From: [Downes, Scott G \(DFW\)](#)
To: [Rachael Stevie \(CD\)](#)
Cc: [Torrey, Elizabeth M \(DFW\)](#)
Subject: RE: SE-18-00008 Sparks Park - Notice of Application WDFW Comments
Date: Tuesday, August 31, 2021 10:21:09 AM

Thank you for sending over the additional documents (road plan and the drainage report) for review. Here are WDFW comments:

SPARKS ROAD  
NATHAN WEIS  
GRADING AND DRAINAGE PLAN

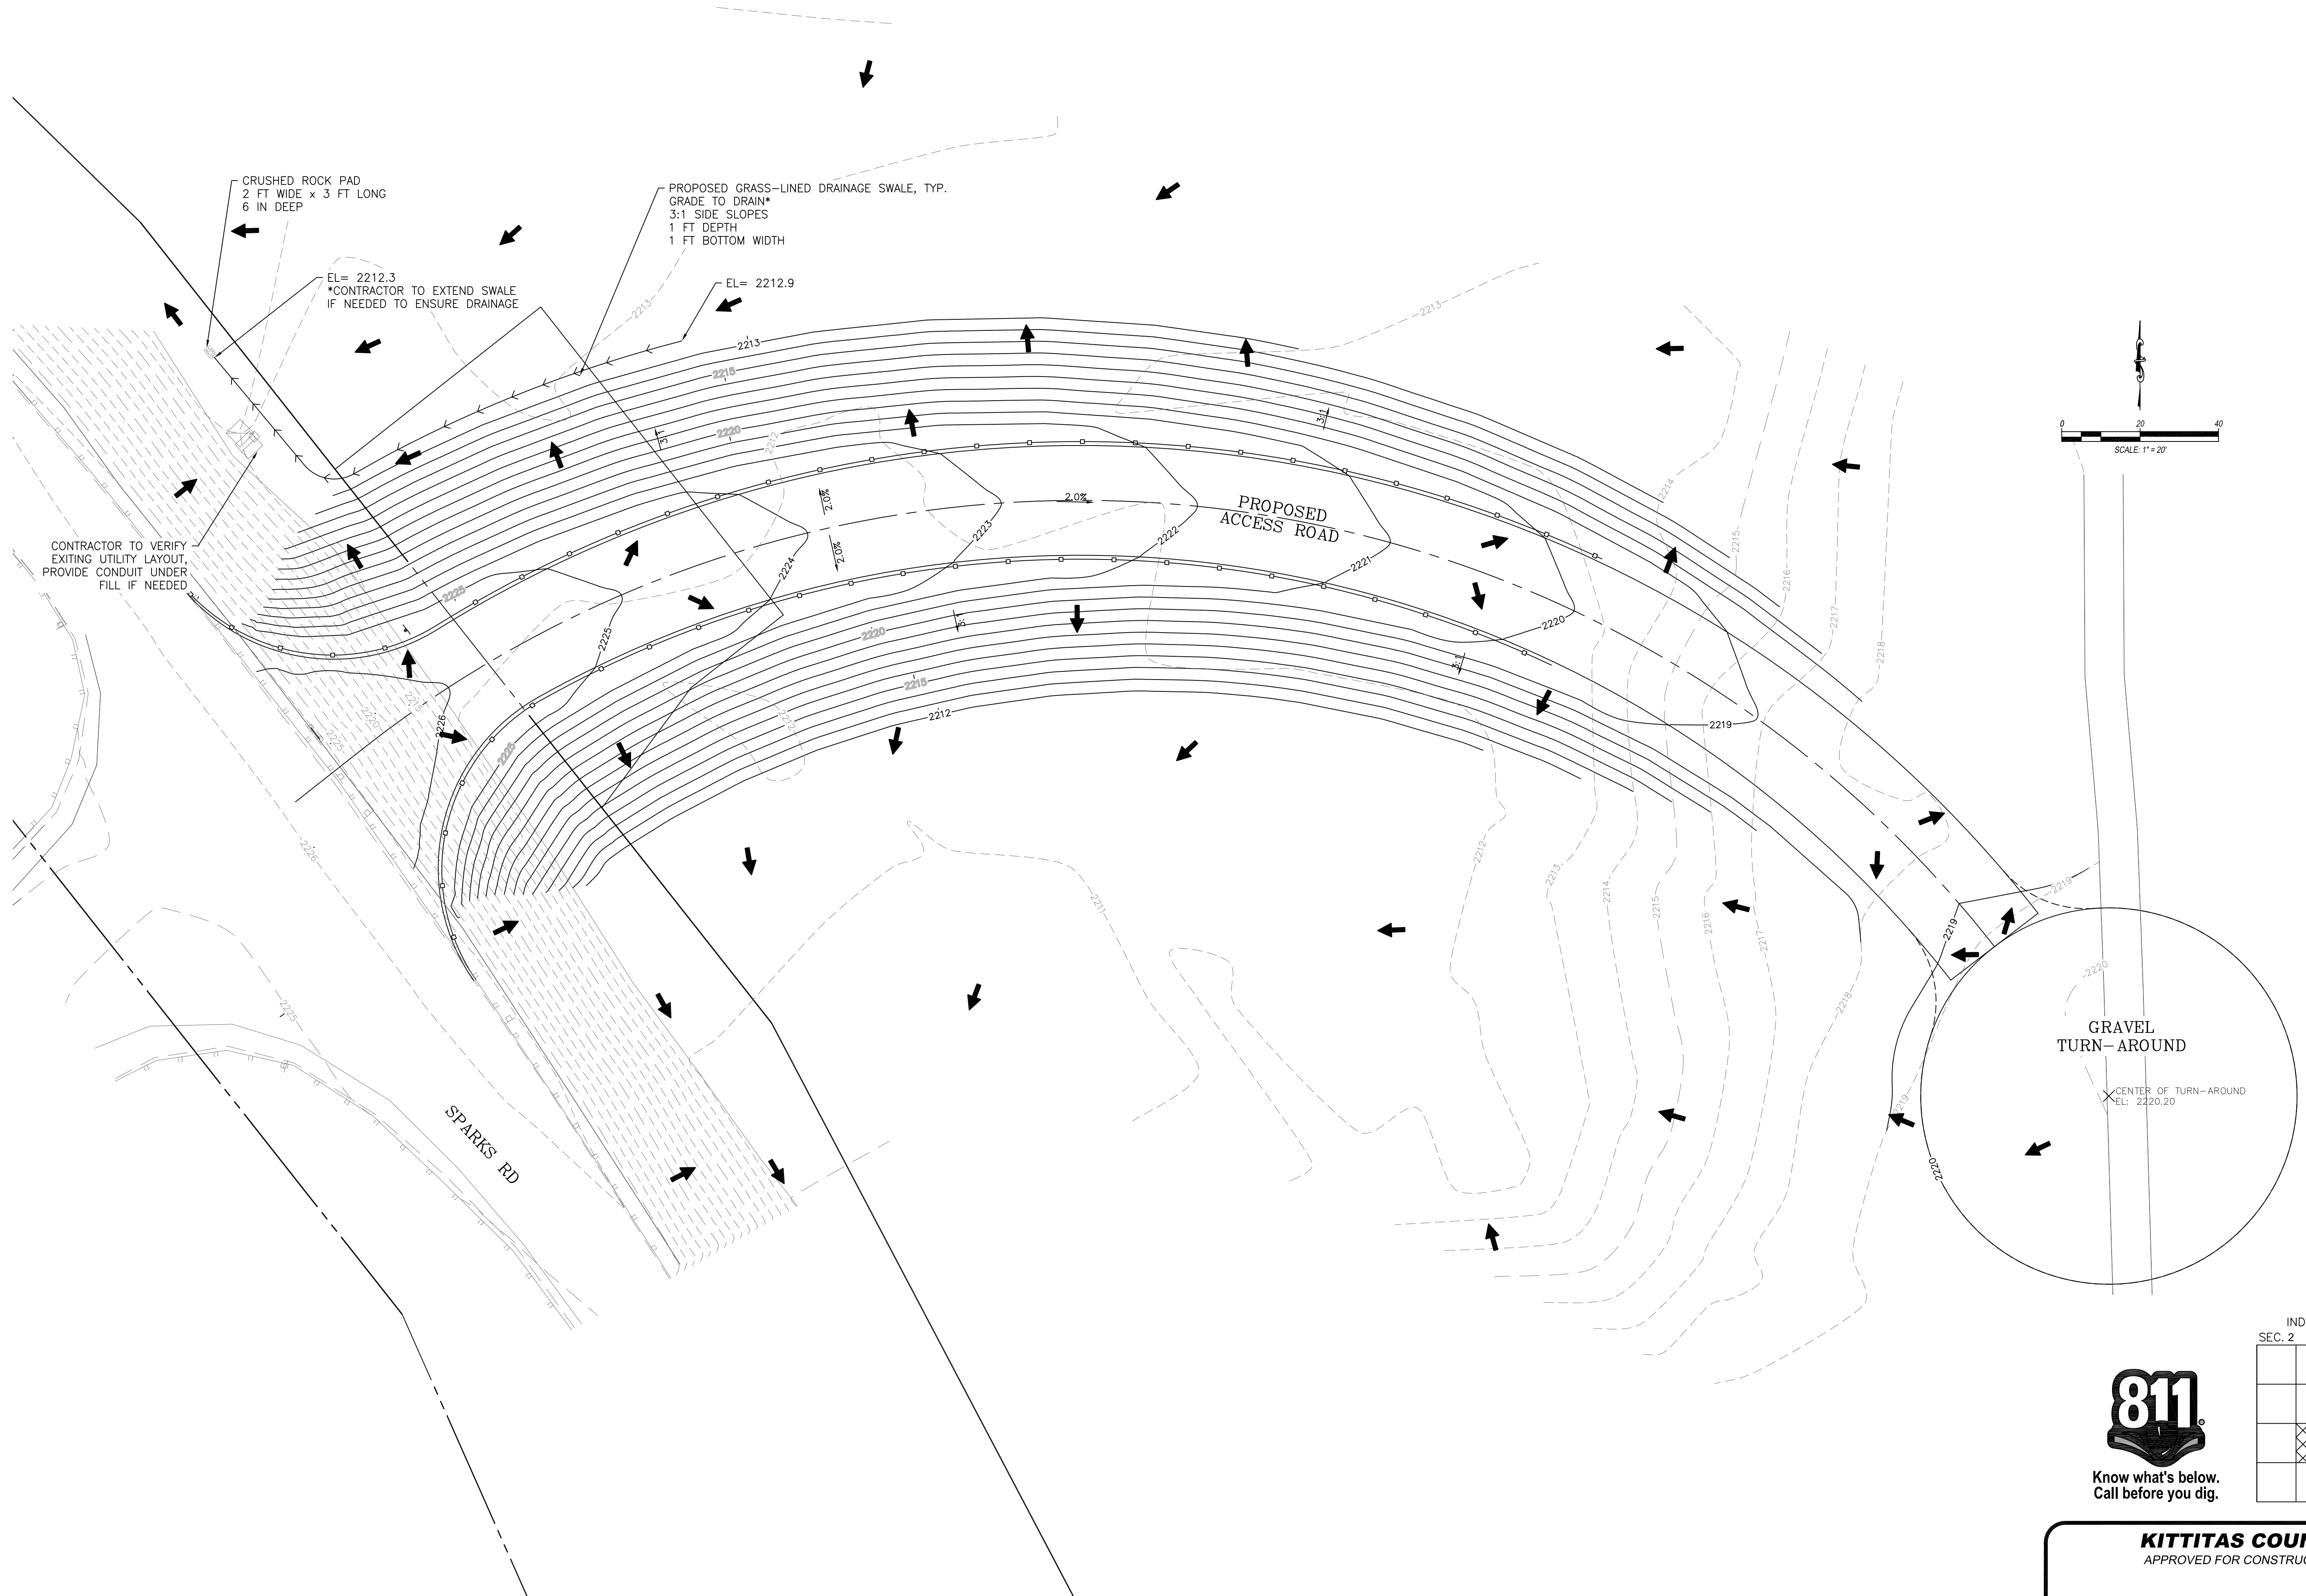
2. Drainage, similar comment on evaluating overall impacts. The drainage report indicates that subsequent development is likely to follow the road building, however is only evaluating the impacts of removed trees and impervious surfaces for the road. A drainage report should not be piecemealed and the entire development of the site should be evaluated for runoff impacts. Drainage from this property is likely to flow through I-90 culverts towards Lake Easton and it is important to evaluate if those culverts are adequately sized and thus a drainage report needs to evaluate all planned activities that will result in land clearing and building of impervious surfaces to adequately evaluate impacts. Thus, WDFW believes that the conclusion of the drainage report: "The project will not add significant runoff to the existing drainage system" is premature and possibly inaccurate until a full drainage report for all planned activities is conducted.

**SPARKS ROAD**  
 NATHAN WEIS  
 ROAD PLAN AND PROFILE

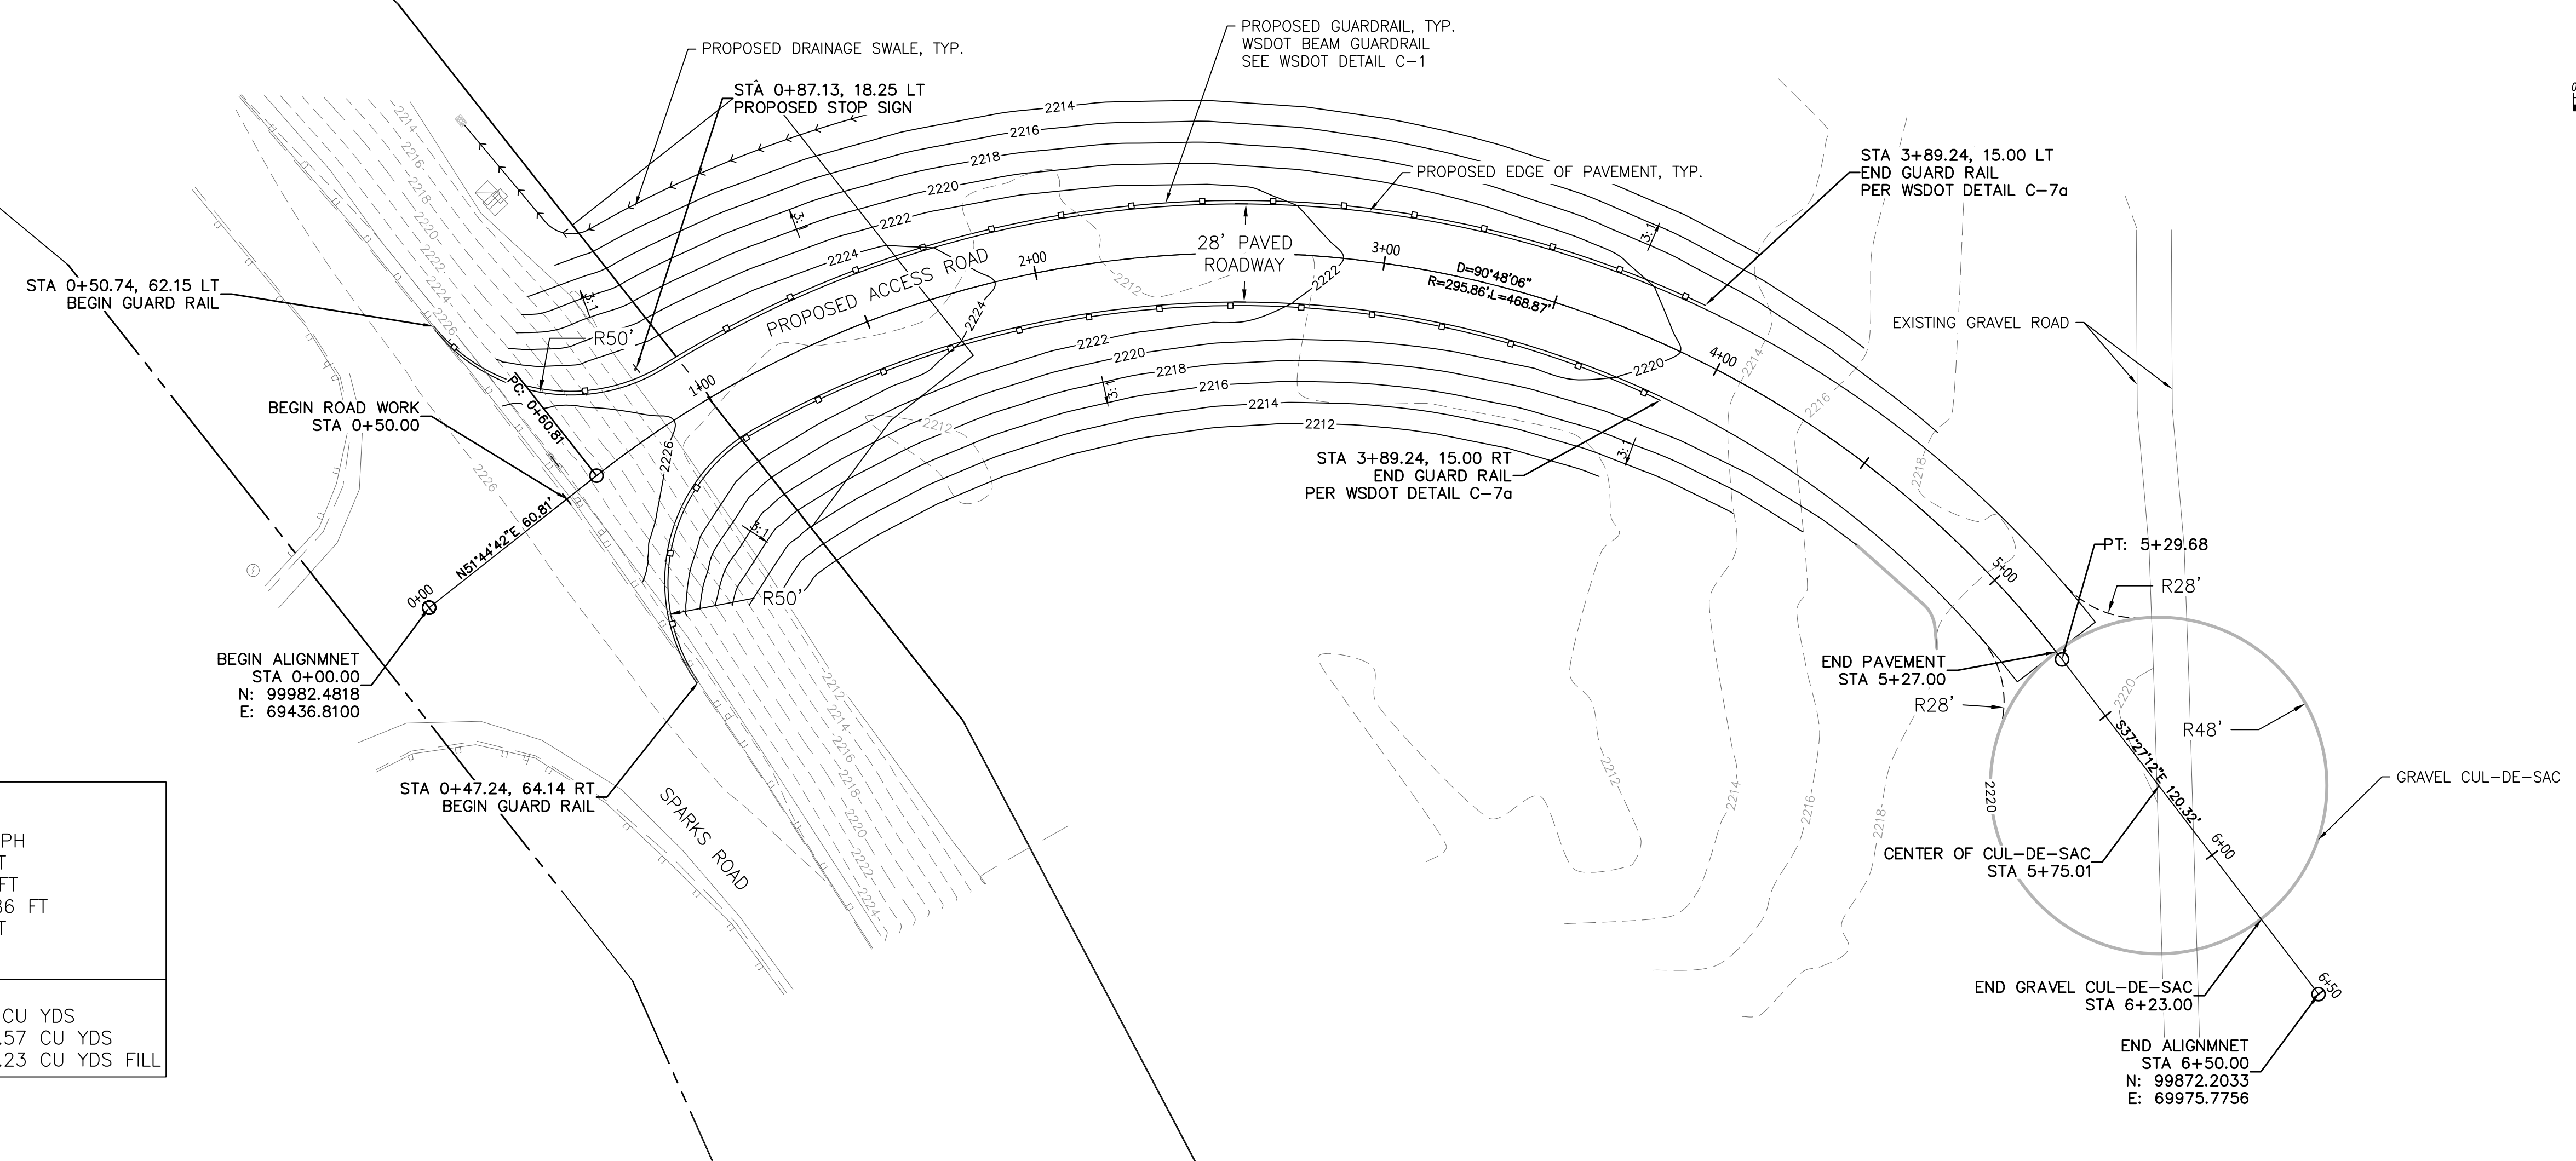
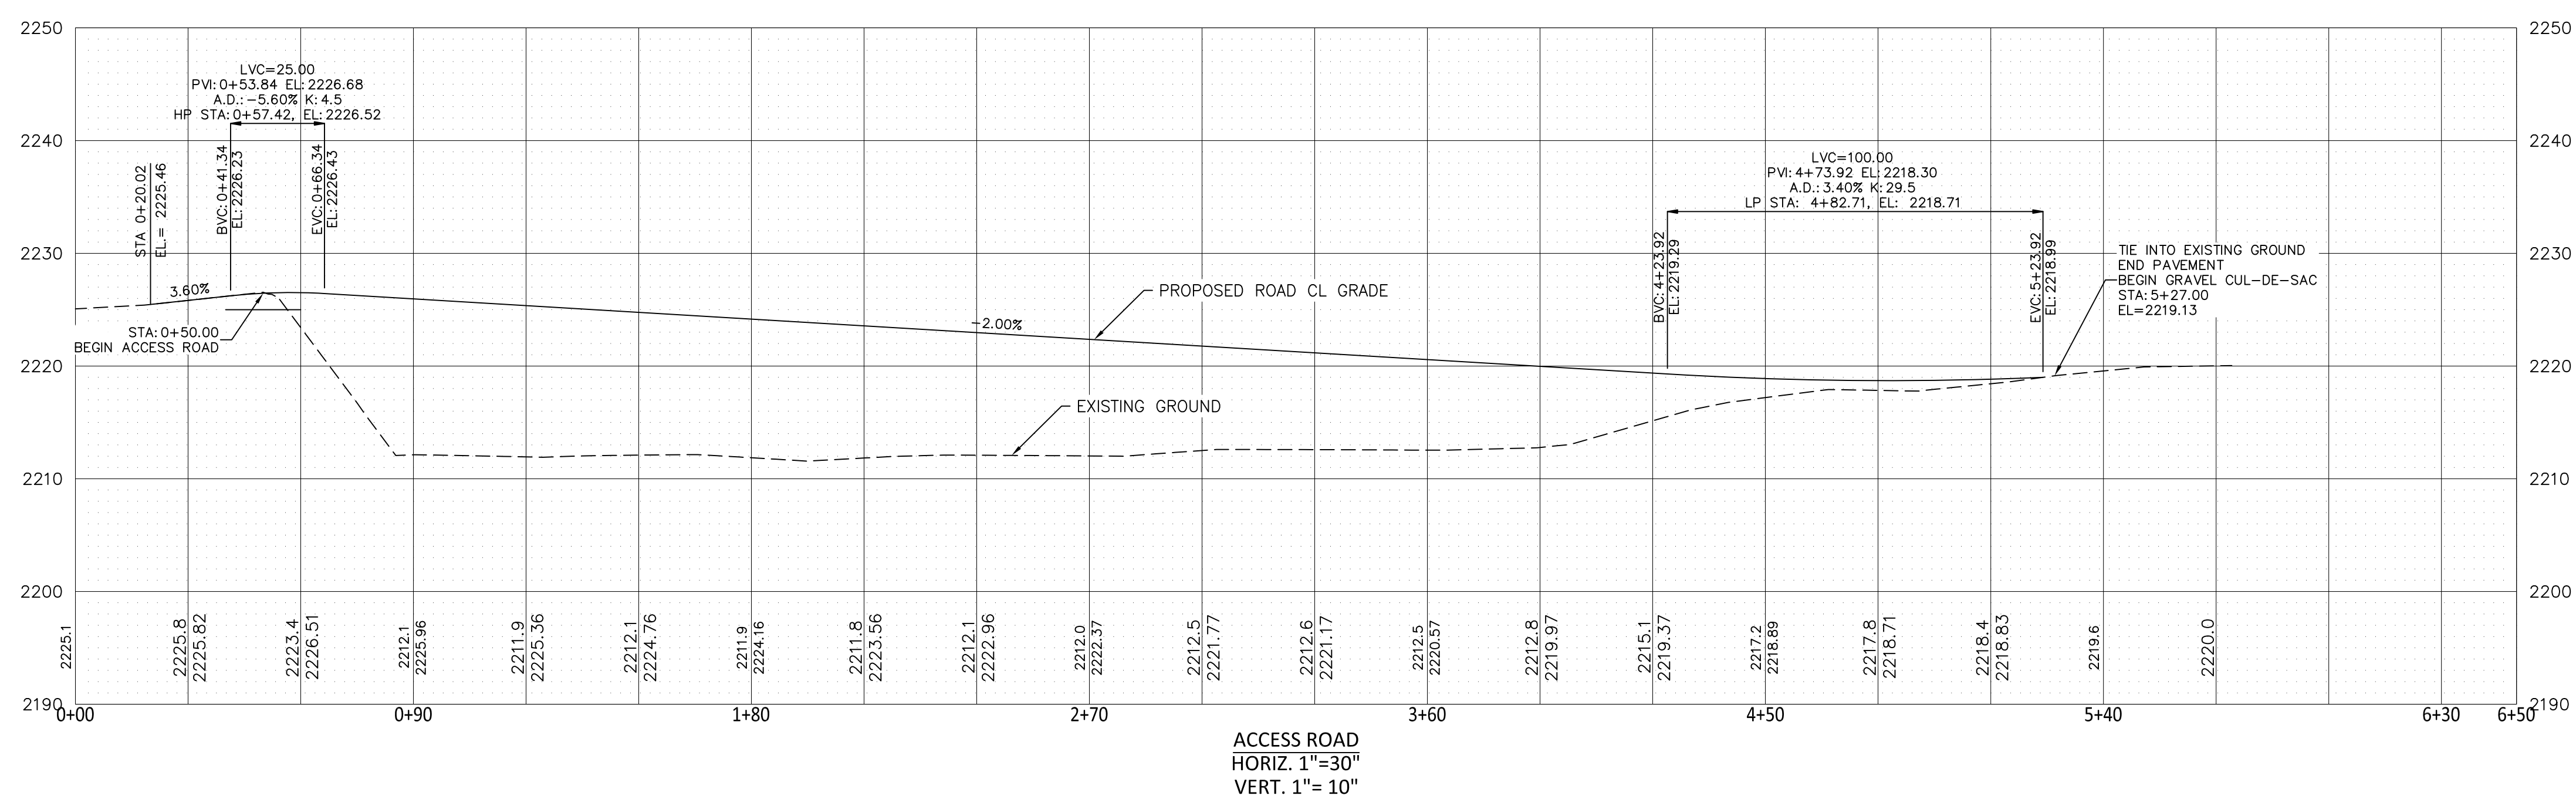
1. The area is located in WDFW PHS designated Elk Wintering Area. While the road itself may not have significant impacts to the habitat, the road is likely to lead to future development (even mentions likely future development in the drainage report). The entire plan (road and future development) needs to be evaluated together and how the habitat impacts potentially can be offset. If only the road is being evaluated now, WDFW requests that at least a placeholder to acknowledge the designated PHS habitat and a condition that the applicant must work with WDFW to minimize impacts for future development and mitigate for those habitat impacts that cannot be minimized.
